From: Guy Edwards
Sent: 04 October 2011 09:49
To: Juan Baeza
Subject: RE: Gunstone Farm

"Gustone Farm Emergency Flood Risk and Rescue Plan"

Title	Emergency Escape Route				
Scale	As shown	At original	A4	© Robert Clark Associates Ltd	
Drawing Number	1381/3.1				Revision
					-

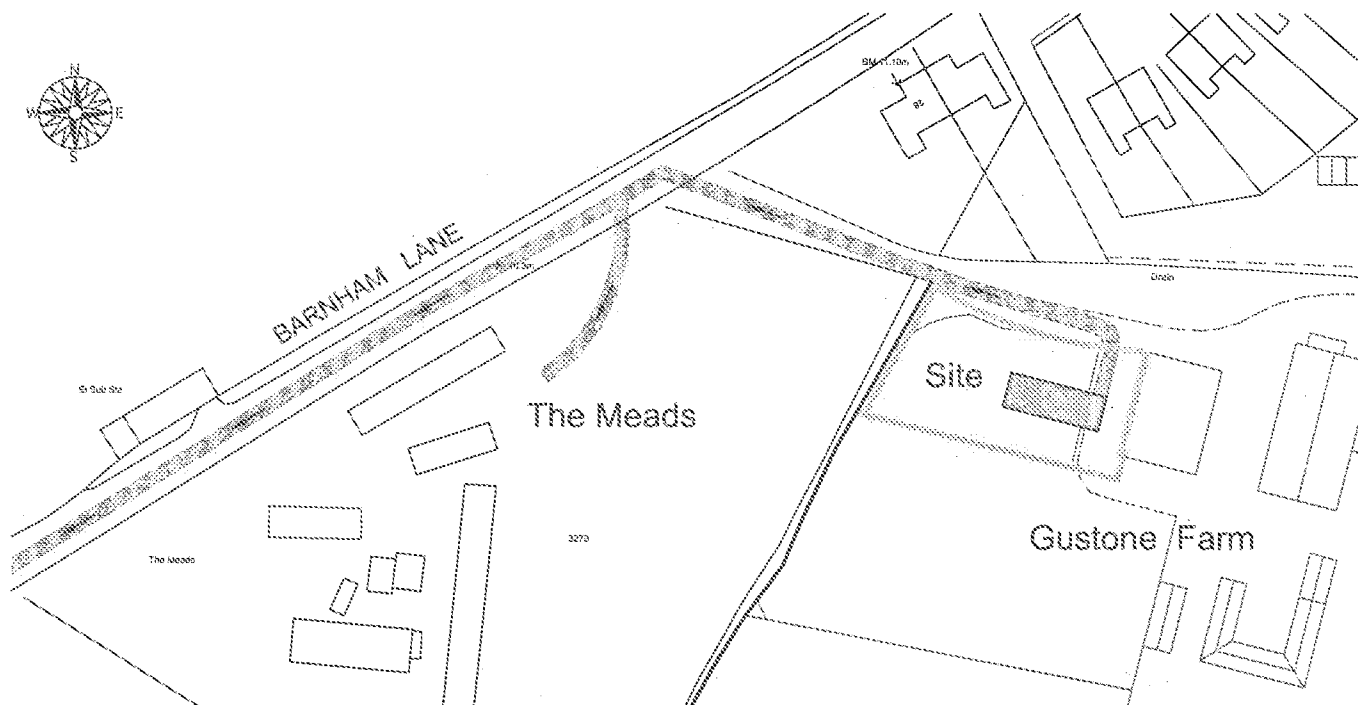
- There is no detail of drawings as to what is being proposed at the site; is it of a new development or what?
- There is no discussion/proposal for the management of Surface Water Flooding to include for proposed attenuation rates for existing discharge rates for storm water discharge and for the overland flows and how the proposed development might be built so as not to impede these
- There is no detail of freeboard level of the ground floor building levels (at ... m AOD) above the modelled 1 in 200 flood event.
- There is no mention of how the building design will add resilience and protection to the users. Mention should include:

- The ground finished floor level (... m AOD) of the building set above the 1 in 200 flood level
- year tidal flood level at the site, projected forward to the expected year of the life of the development
- Building design features so that potential flood damage would be minimised in the event of a rare flood, in excess of 1 in 200 year event. Such as:
 - ... Concrete floor with waterproof membrane
 - ... Sealed service ducts
 - ... Locate electrical and other plant on first floor
 - ... High level electrical sockets
 - ... Optimise security of supplies
 - ... Anti-slip surfaces on walkways
 - ... Emergency lighting with power source above flood level
